Whalley Parish Council

PLANNING APPLICATION 3/2012/0179

© Harrison & Pitt
Residential Units at Accrington Road
Whalley
for Briery Homes
PROPOSED SITE PLAN
1637-040 P4 1:500 @ A2

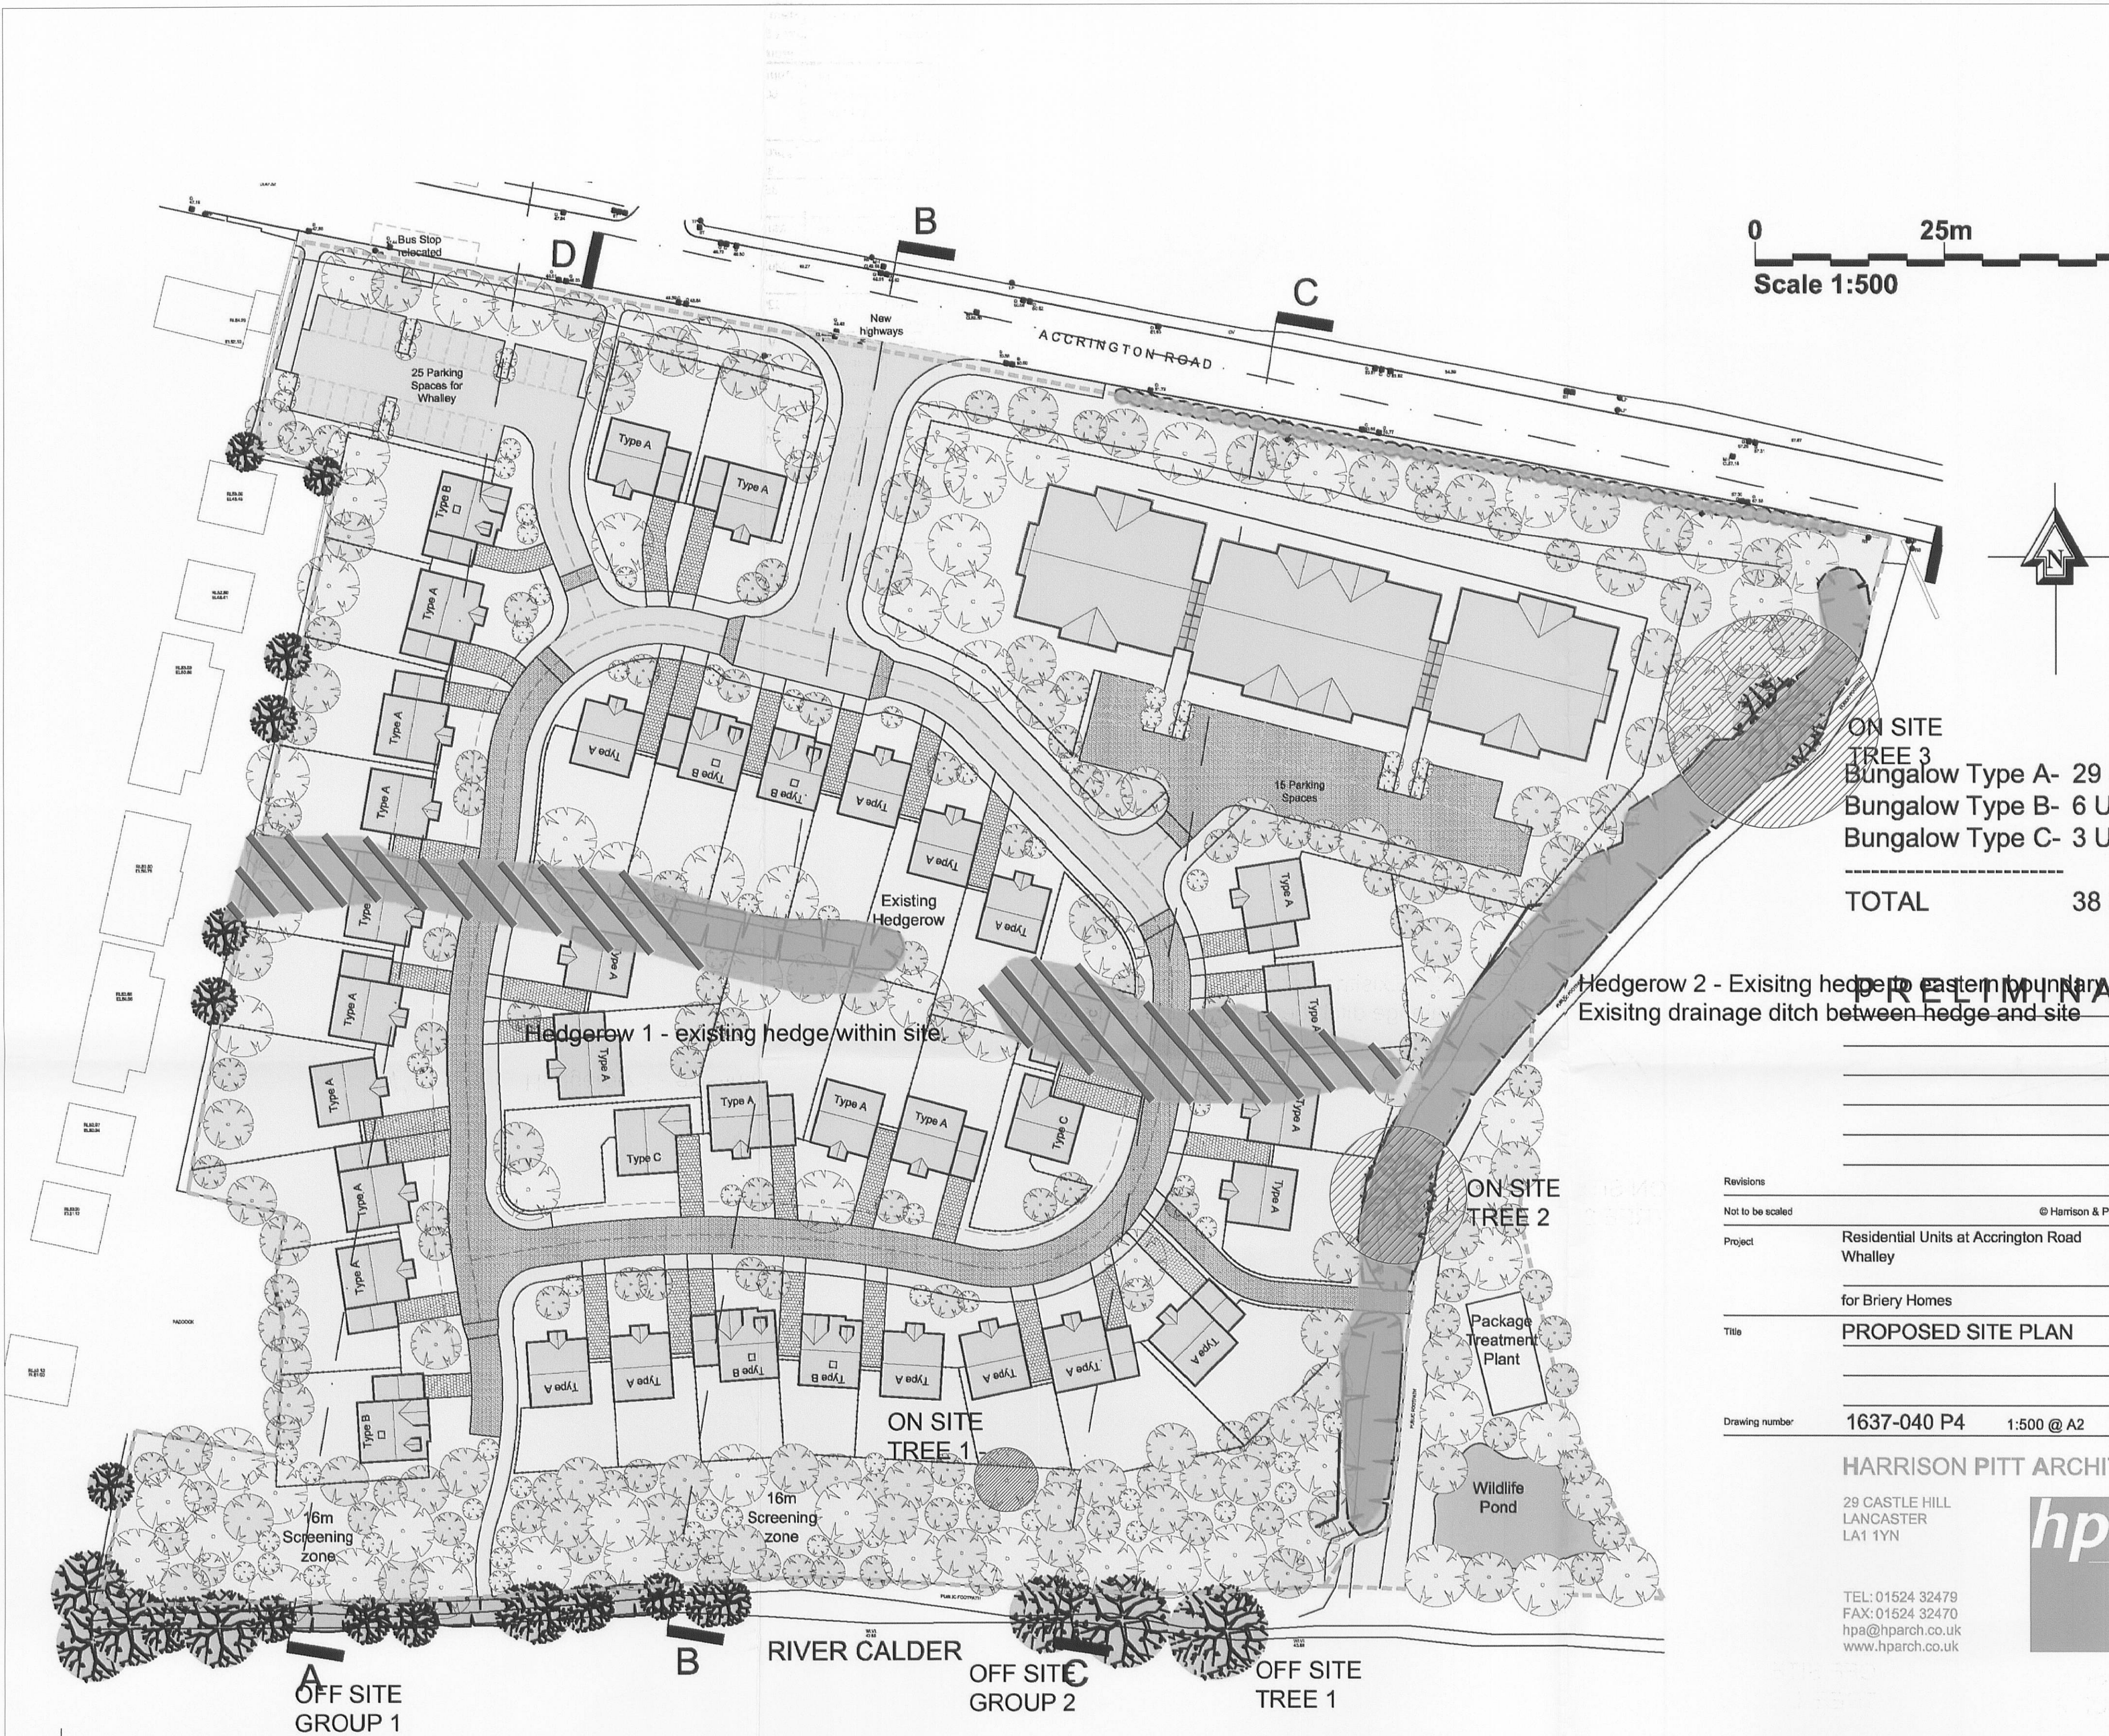
The present applications planned parking area is not be enough for residents and visitors. They in turn will be displaced and have to park elsewhere, presumably along the already congested Accrington Road.

To alleviate to some extent, although not to eradicate totally these problems, the parish council urge RVBC officers and councillors to seek an amendment to the above application by increasing the amount of car parking space on site. This additional car parking should then be made available to the Whalley community.
